From: [Mark Peacock](#)
To: [Planning](#)
Subject: FW: Hatfield. KFC Former De Haviland Building, Comet Way.16/1007/FUL, 1008/ADV, 1089/LB
Date: 06 August 2016 09:05:43

From: Andrew Robley
Sent: 05 August 2016 18:35
To: Mark Peacock
Subject: Hatfield. KFC Former De Haviland Building, Comet Way.16/1007/FUL, 1008/ADV, 1089/LB

drawing title  
**PROPOSED ELEVATIONS**

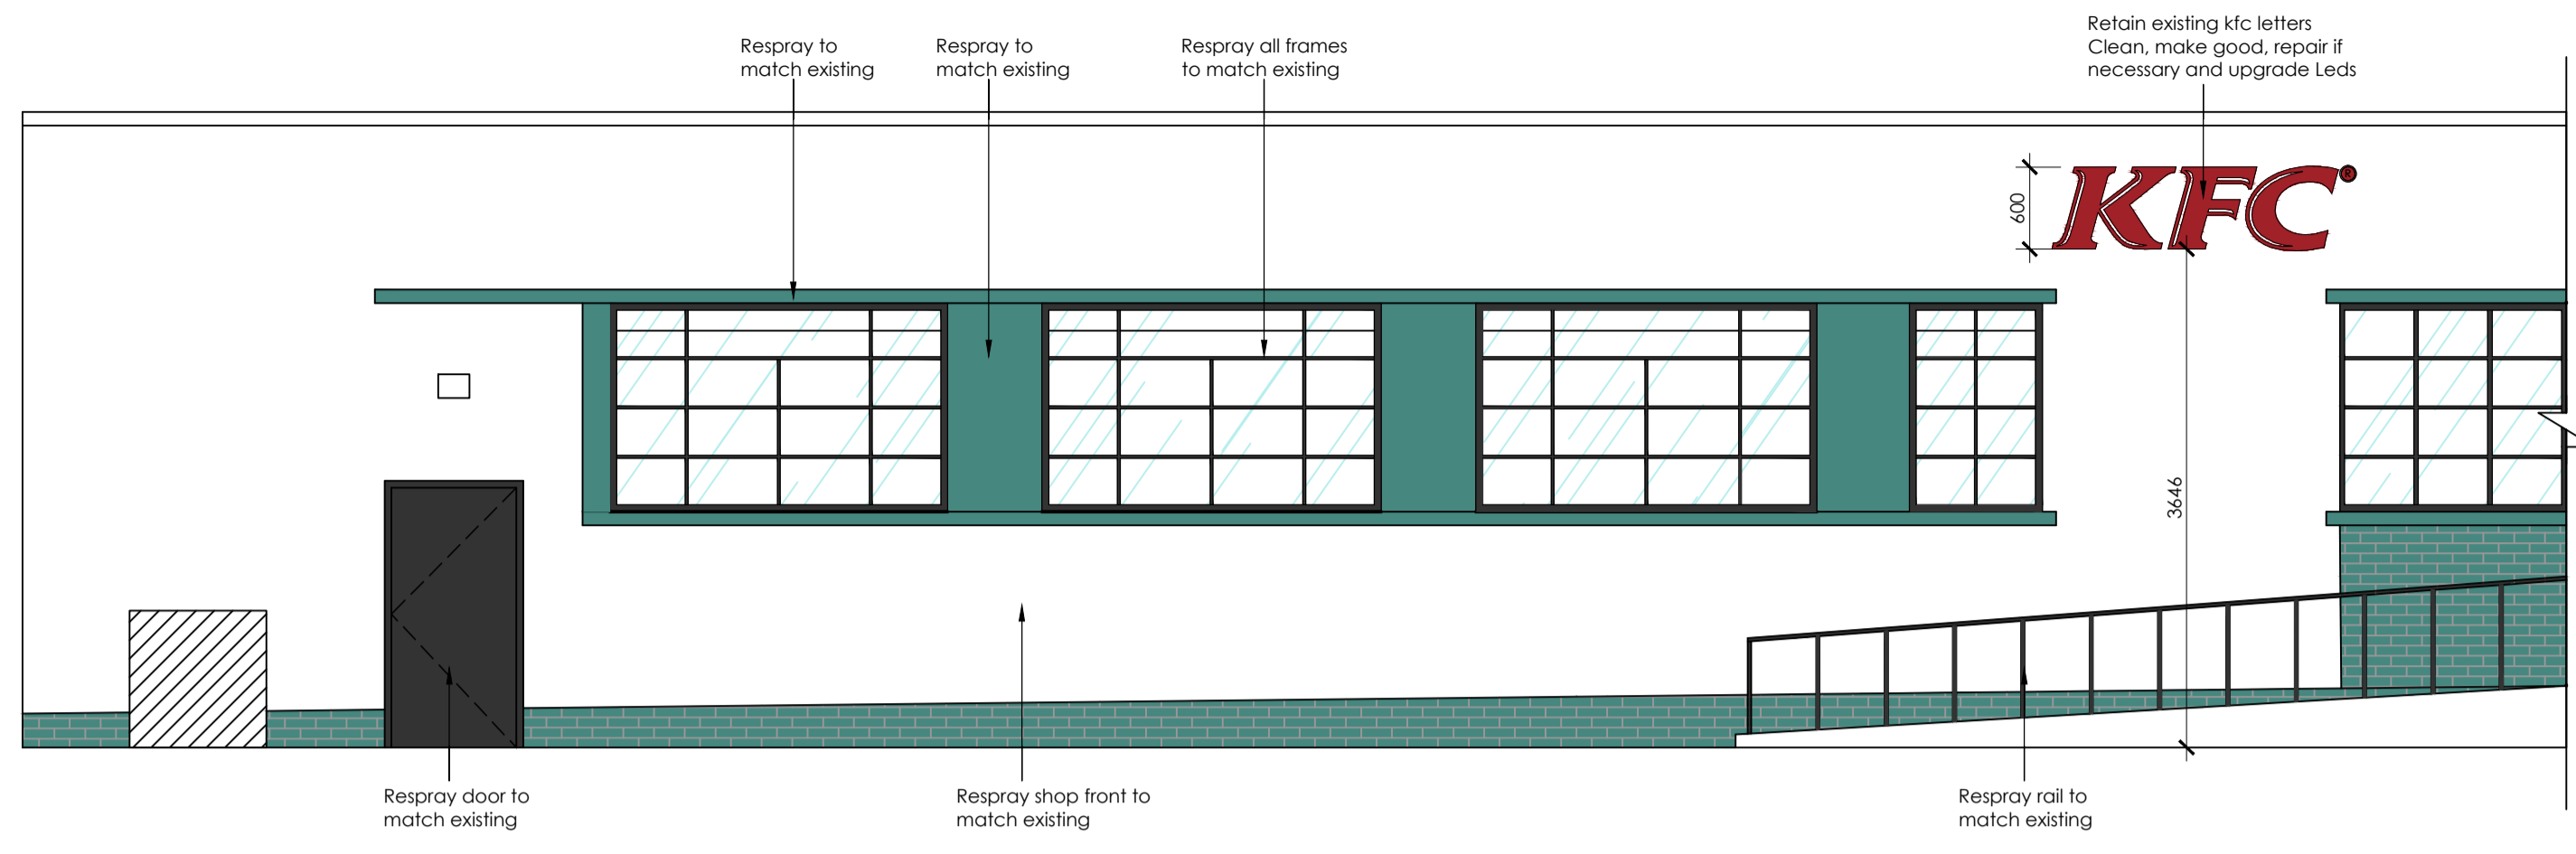
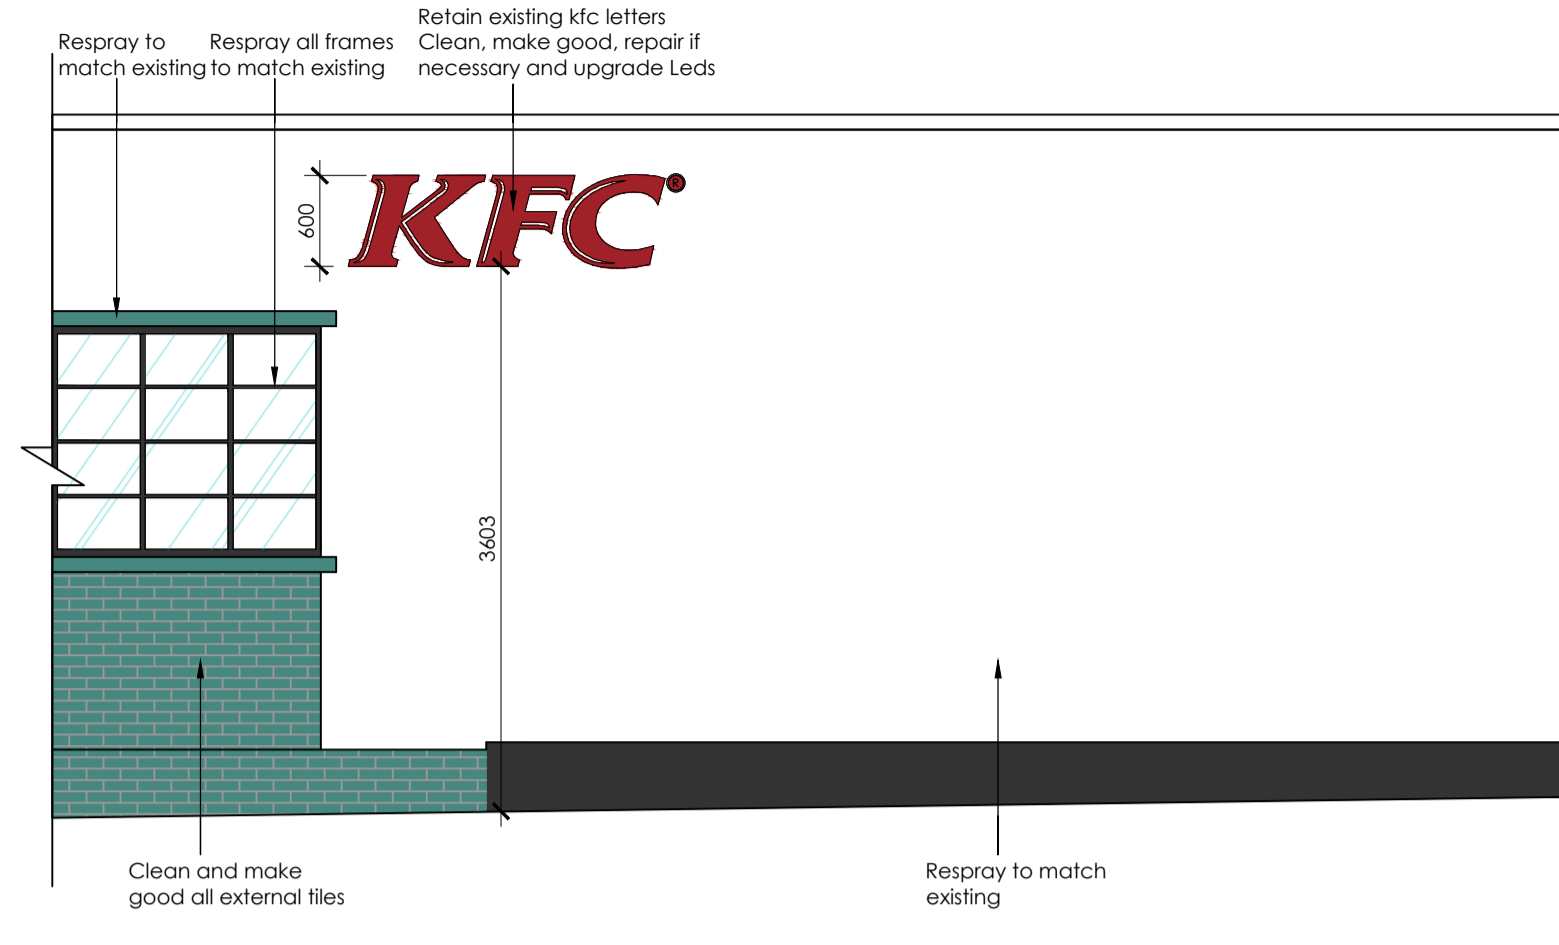
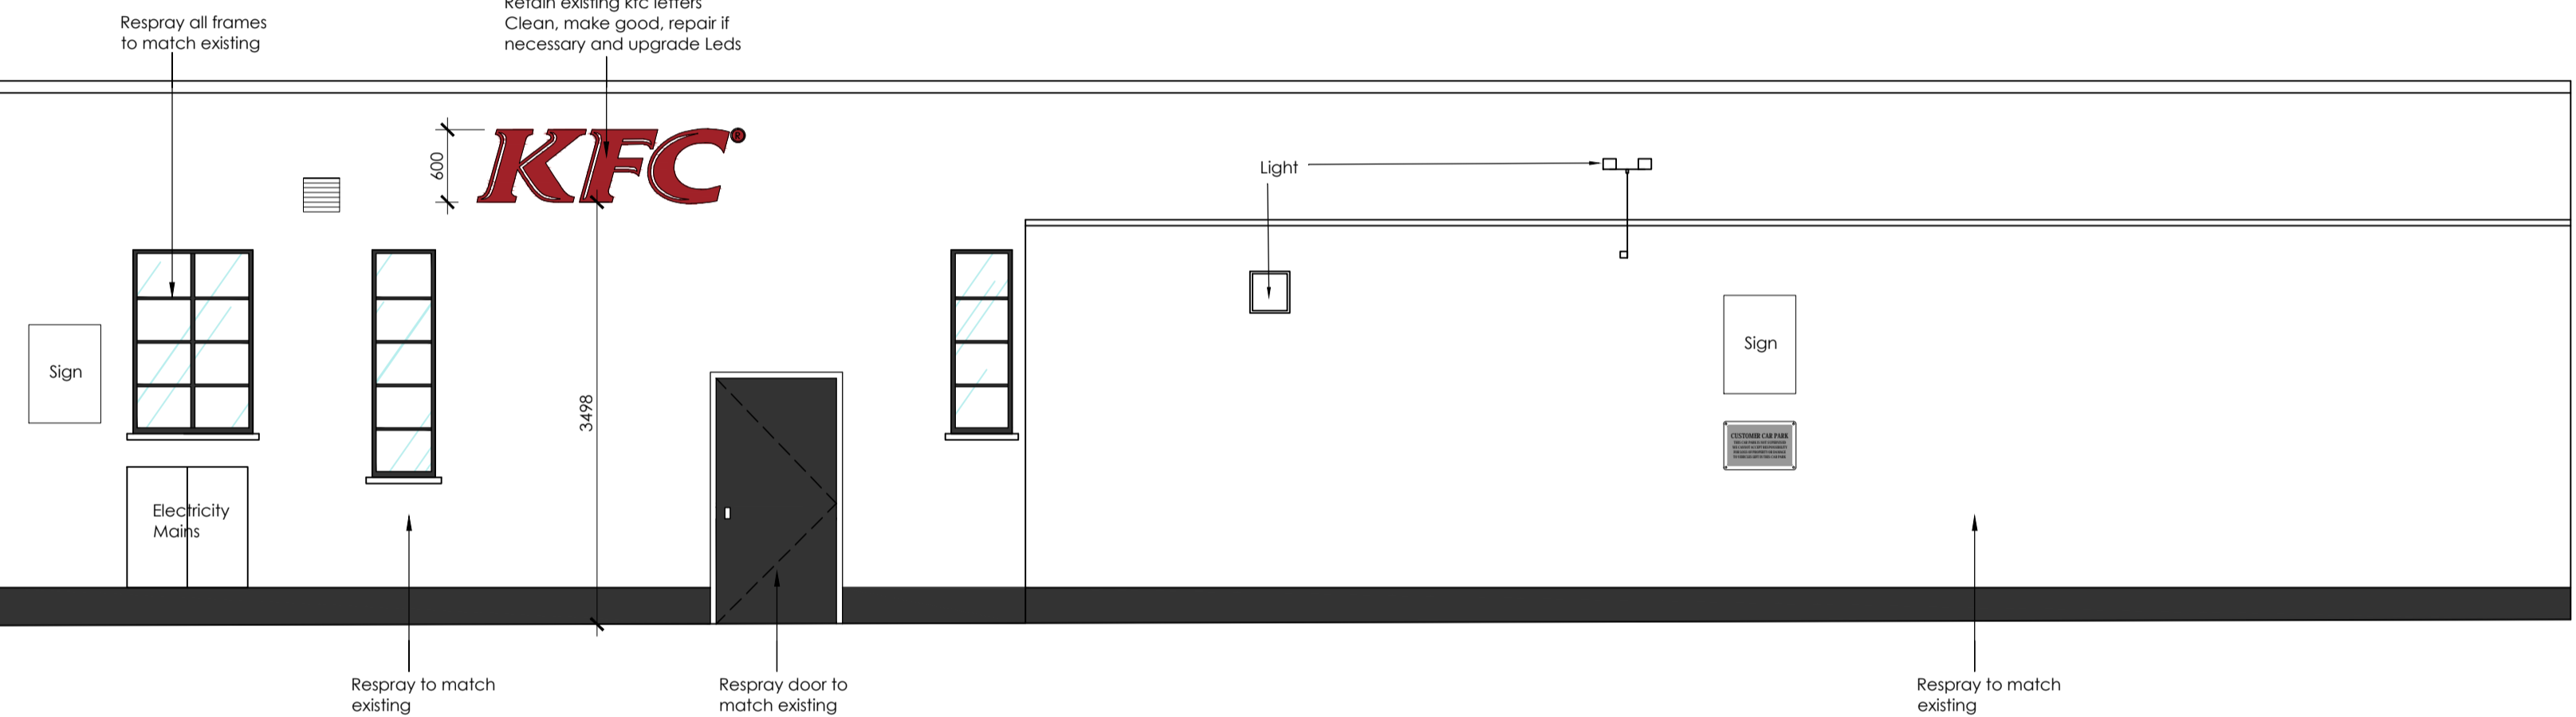
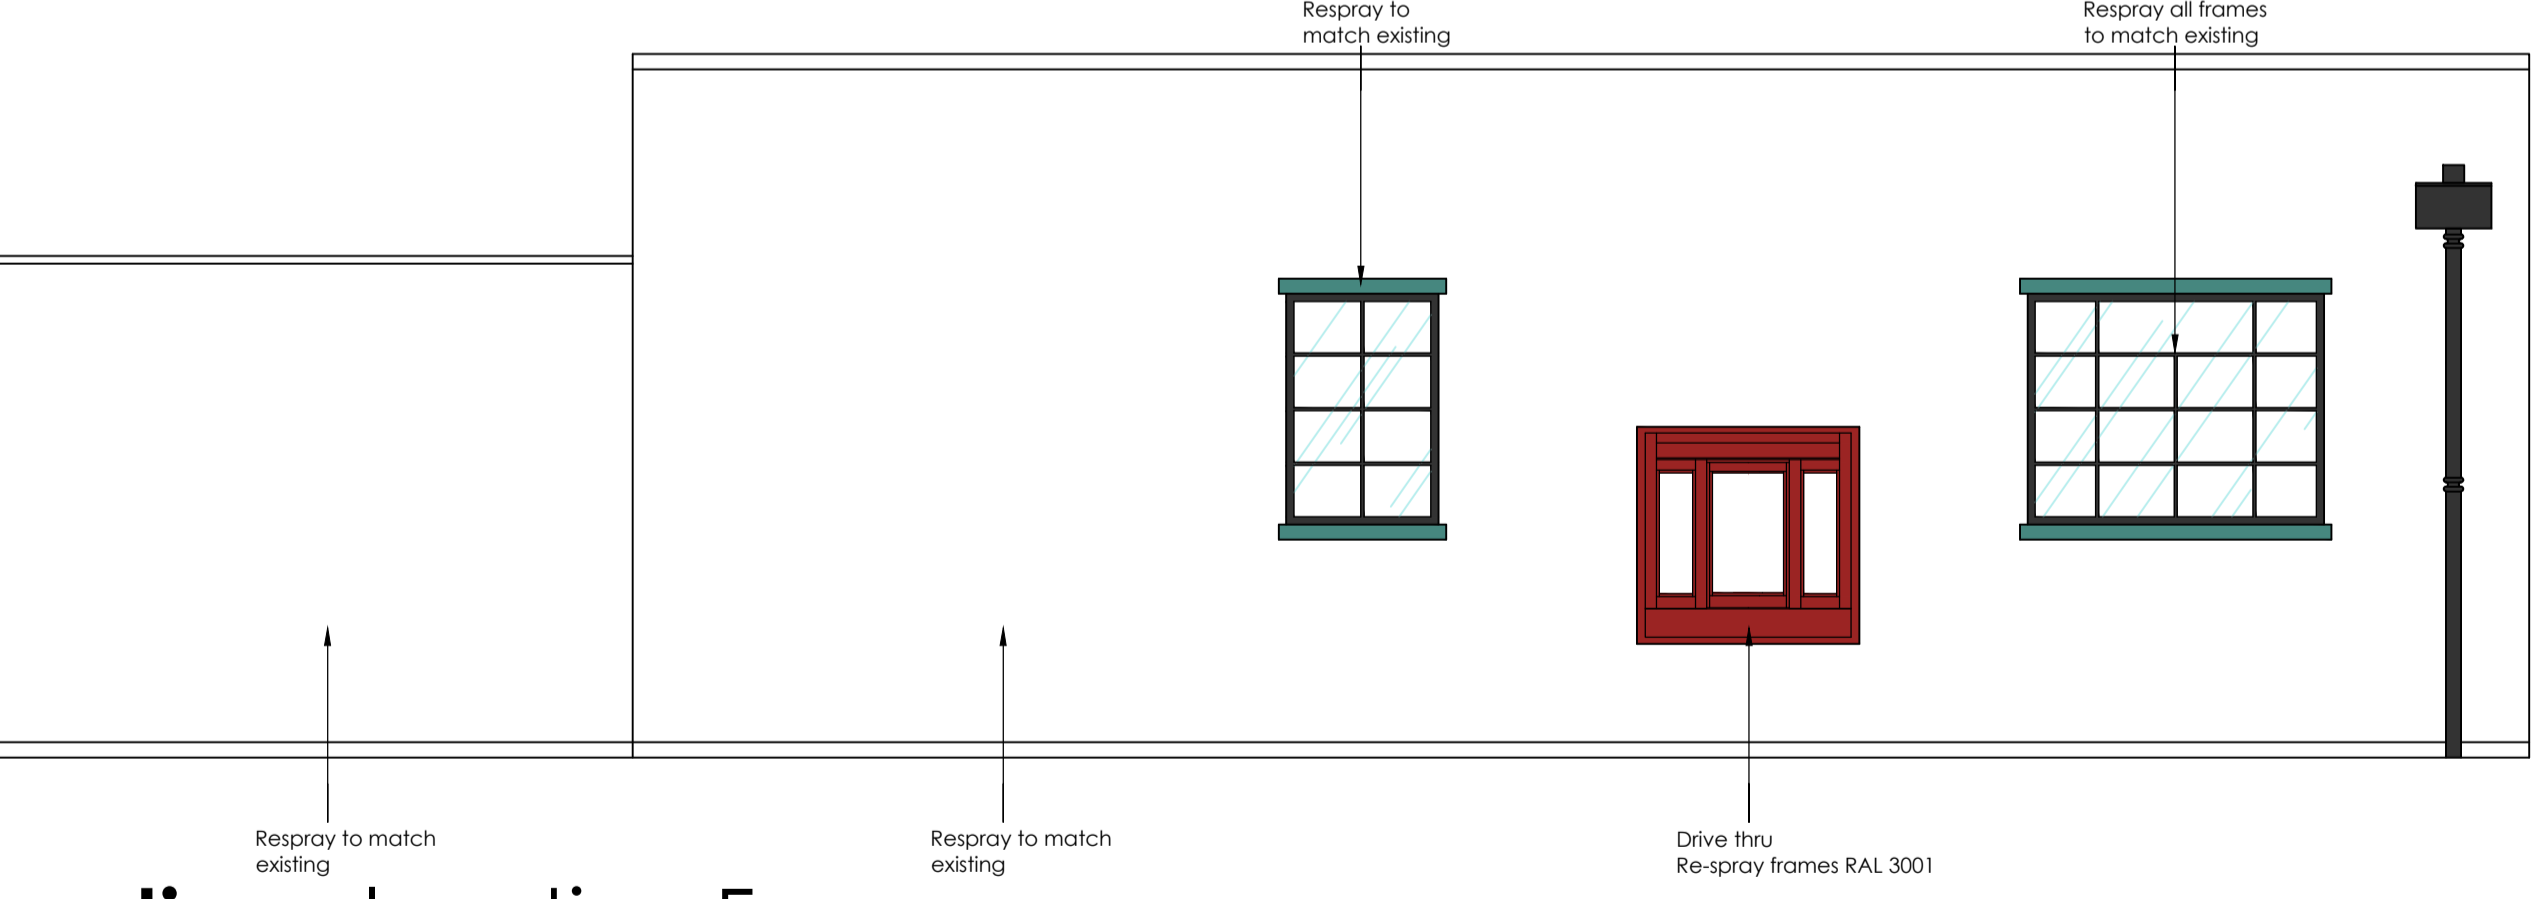
I can't see any changes on the building except for respraying windows, doors and spandrels the same colour green. This is Ok but the green must be exactly the same. However the "Drive Thru frames" would be sprayed an unacceptable red. On the building they must be the same green or if they must have a contrast, the grey RAL7022 they are using elsewhere.

The doors that are shown to be resprayed the same colour as at present would be better in the same green but if they already have consent in the darker colour it is reasonably acceptable.
